**M2 Site within the North Ryde Station Urban Activation Precinct SSD
5093**

North Ryde Station Precinct

State Significant Development Application – M2 Site

19 September, 2014

FIGURE 2 – PROPOSED GFA ALLOCATION PLAN (SOURCE: BATES SMART ARCHITECTS)

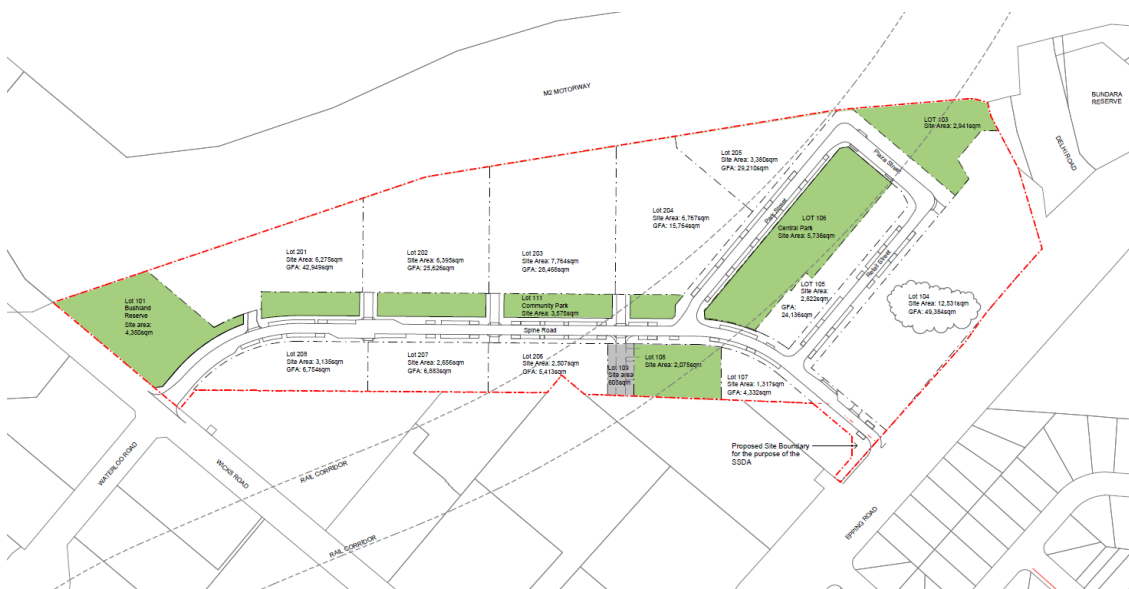
- Zone Q has low FSR to transition to the business park and business core land zones and the permissible heights and FSRs within these. The low FSR within the LEP for Zone Q recognises the fact that a road will go through the site. Indeed all of the existing FSRs within Ryde LEP recognise that there will be new public and estate roads delivered within the site.
- Zone V1 is proposed to have a small decrease in GFA in the order of 7%.
- Zone X is proposed to also have a decrease in GFA of approximately 14%.
- Zone V3 is proposed to have an increase in the order of 0.007%.
- Zone W is proposed to have an increase in GFA of approx.157%.

- Zone W is the second smallest zone on the site with a height limit of 75m under the provisions of the Ryde LEP. Relocating substantial GFA to this zone without increasing the height limit will lead to bulky buildings with larger floor plates. Larger floor plate residential towers are less likely to meet SEPP 65 and more likely to cast shadows that are broad and deep. (Slender buildings cast shadows that move off other sites more quickly and therefore have less impact on neighbours). Council would not support any increases in heights.

- The proposal to reallocate substantial Floor Space to zone W is not supported because:
 - FSR / permissible floor space is not a right and developers may choose to provide less – as this may lead to better design outcomes, respond to market conditions or other constraints.

- Zone W and Zone Q are the least suited to an increase in FSR due to their small site area and the built form that will be created as a result.
 - Zones X and V1 are the better options for accommodating increased GFA because they have higher height limits and the built form outcomes will be better. Having said that the differences in relation to moving GFA should be minimal and in the order of +/- 10% for any zone.

Site Plan

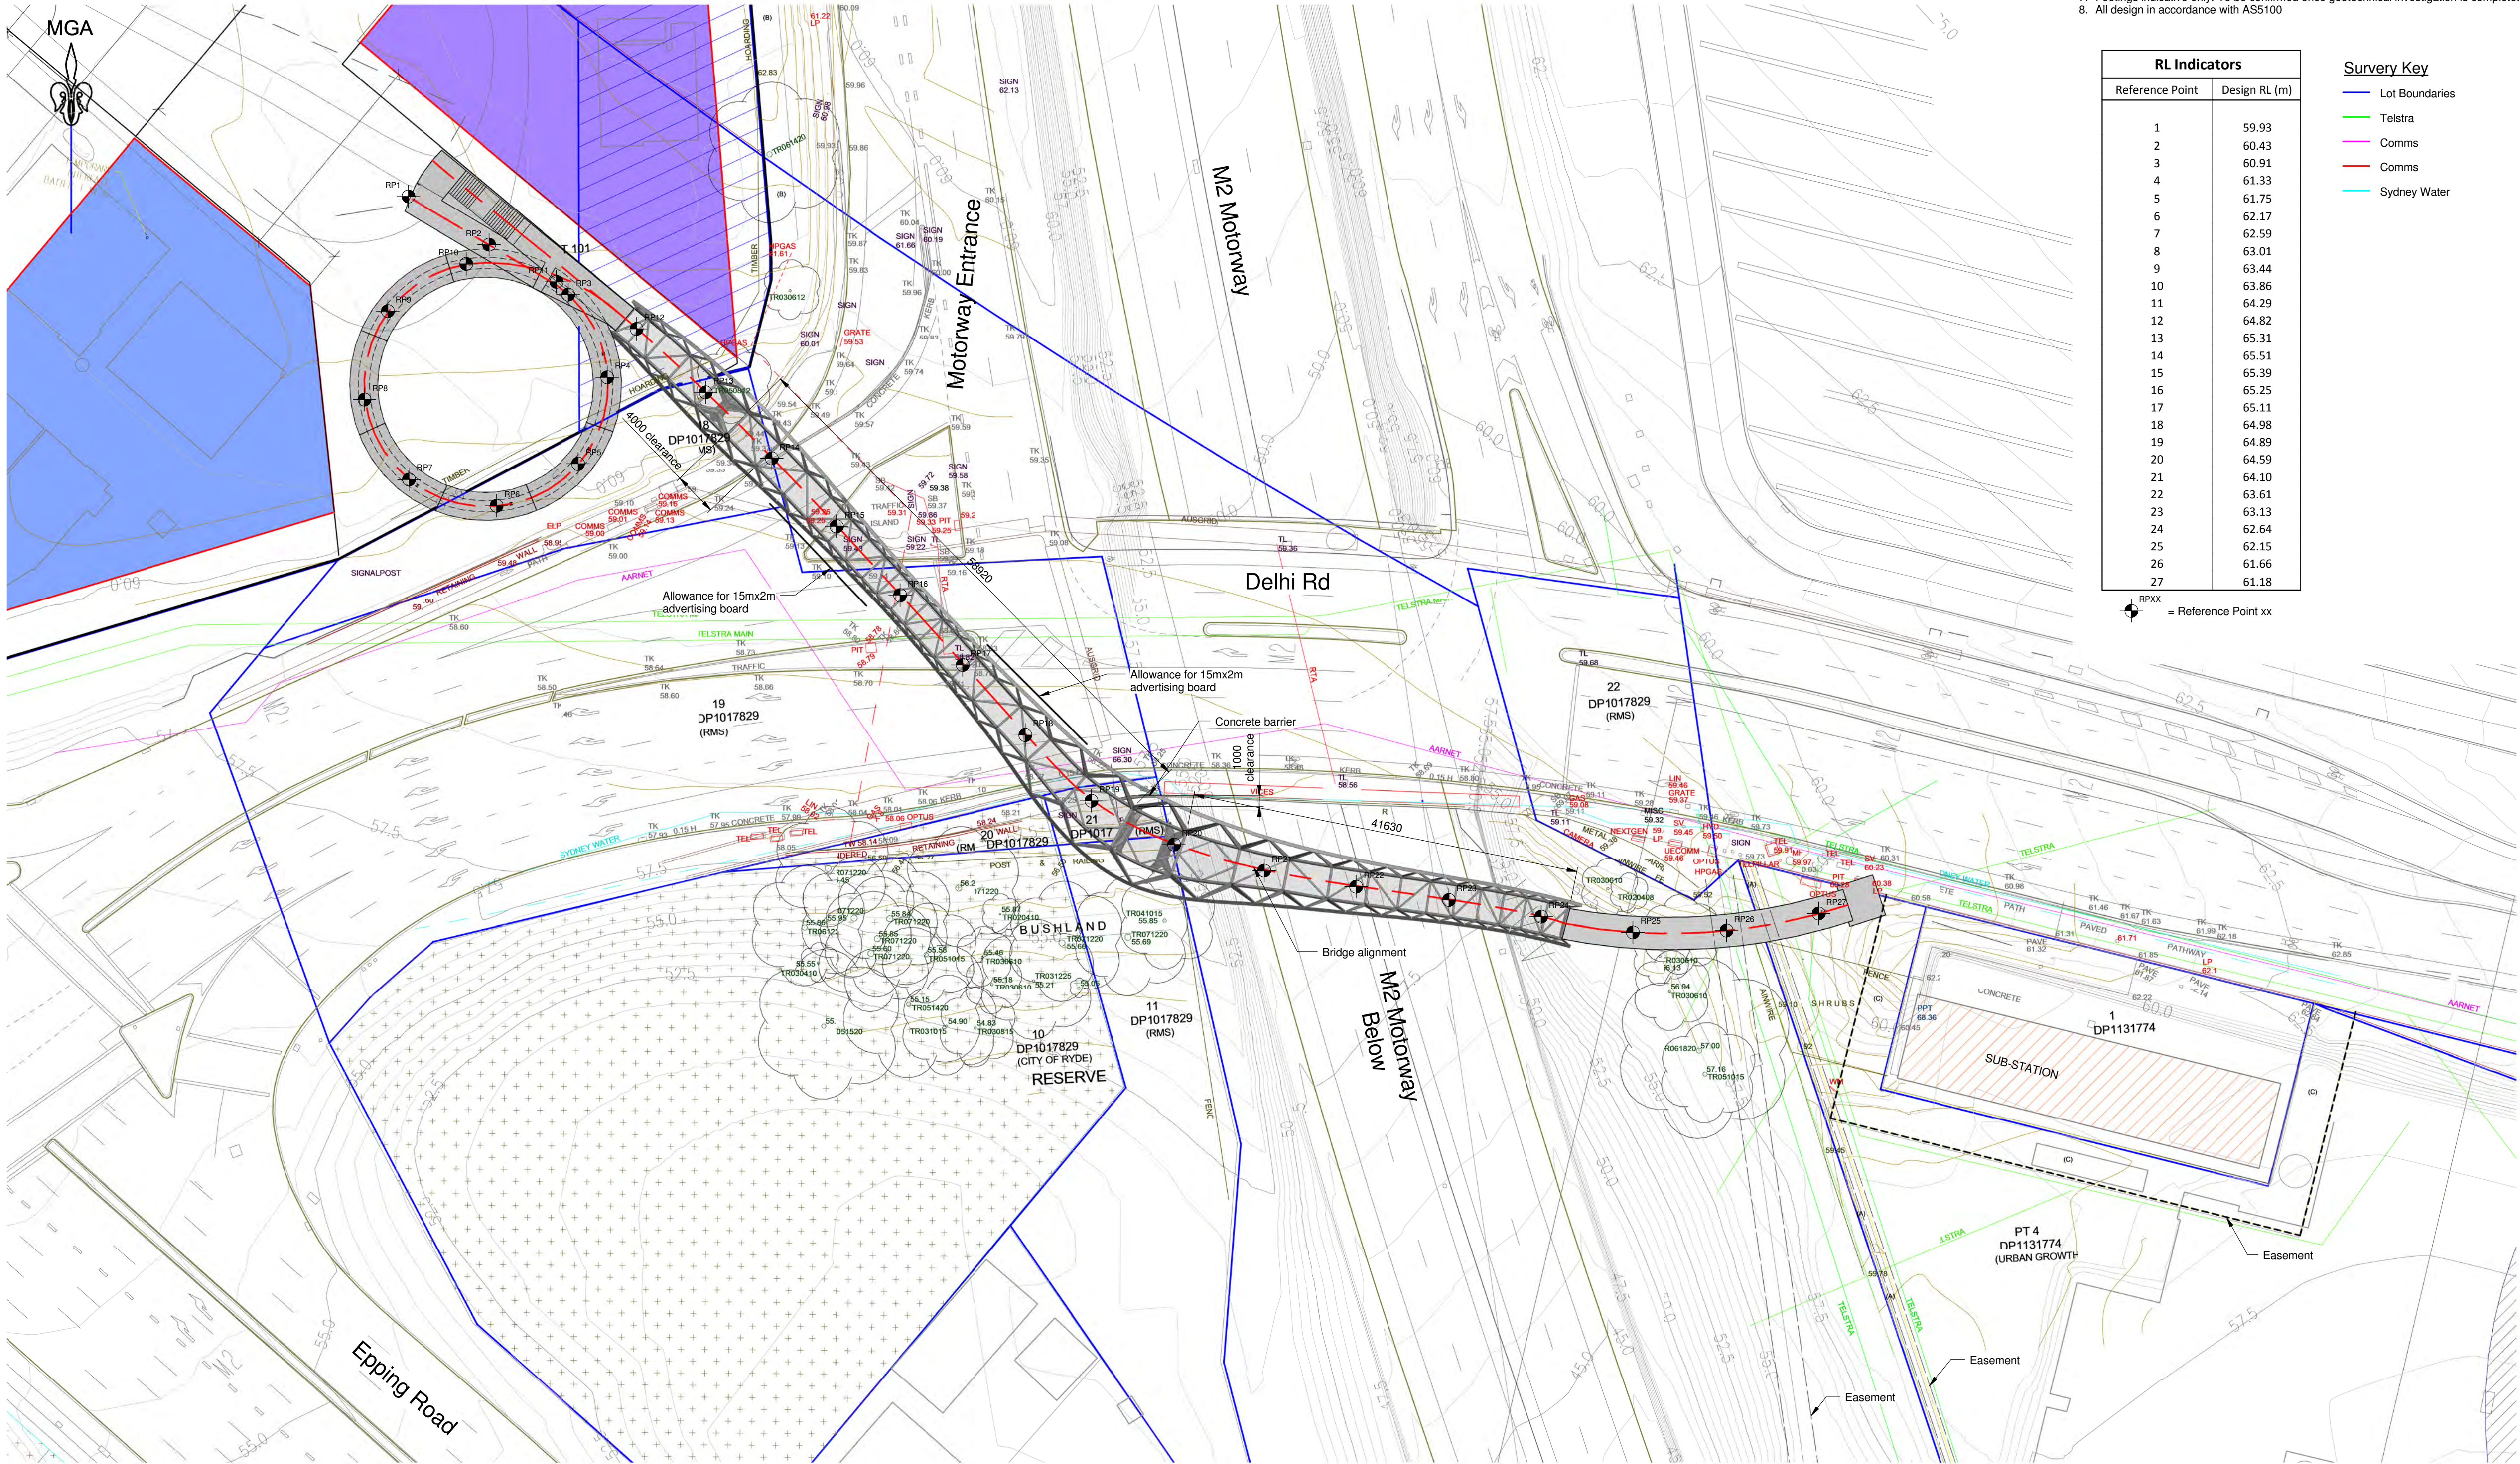
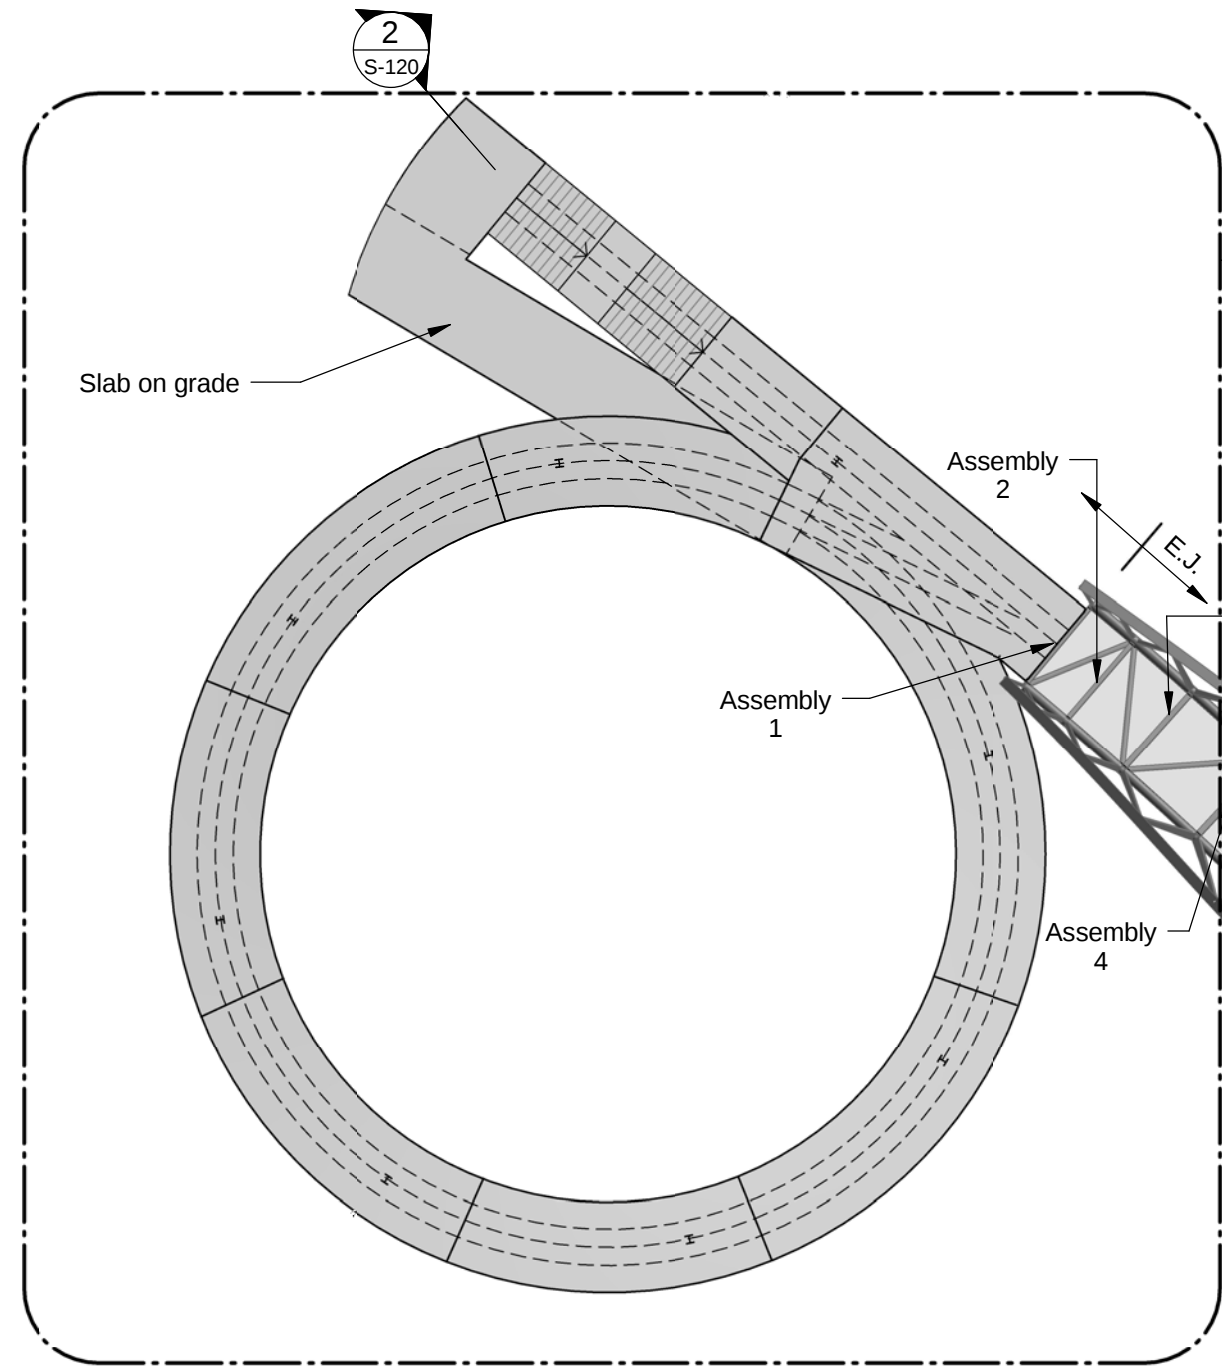
Council has been in discussions with UGNSW regarding the funding of the infrastructure to be delivered under this SSDA and the possibility of a Voluntary Planning Agreement between Council and UGNSW. In this respect, it is noted that the funding, bridge landing details and commentary on the community facility contained within the SSDA are obsolete. During discussions between Council and UGNSW, the community facility is no longer proposed to be a “sports-court” type facility and the proposed bridge landing design onto the M2 site cannot be achieved due to impractical gradients.
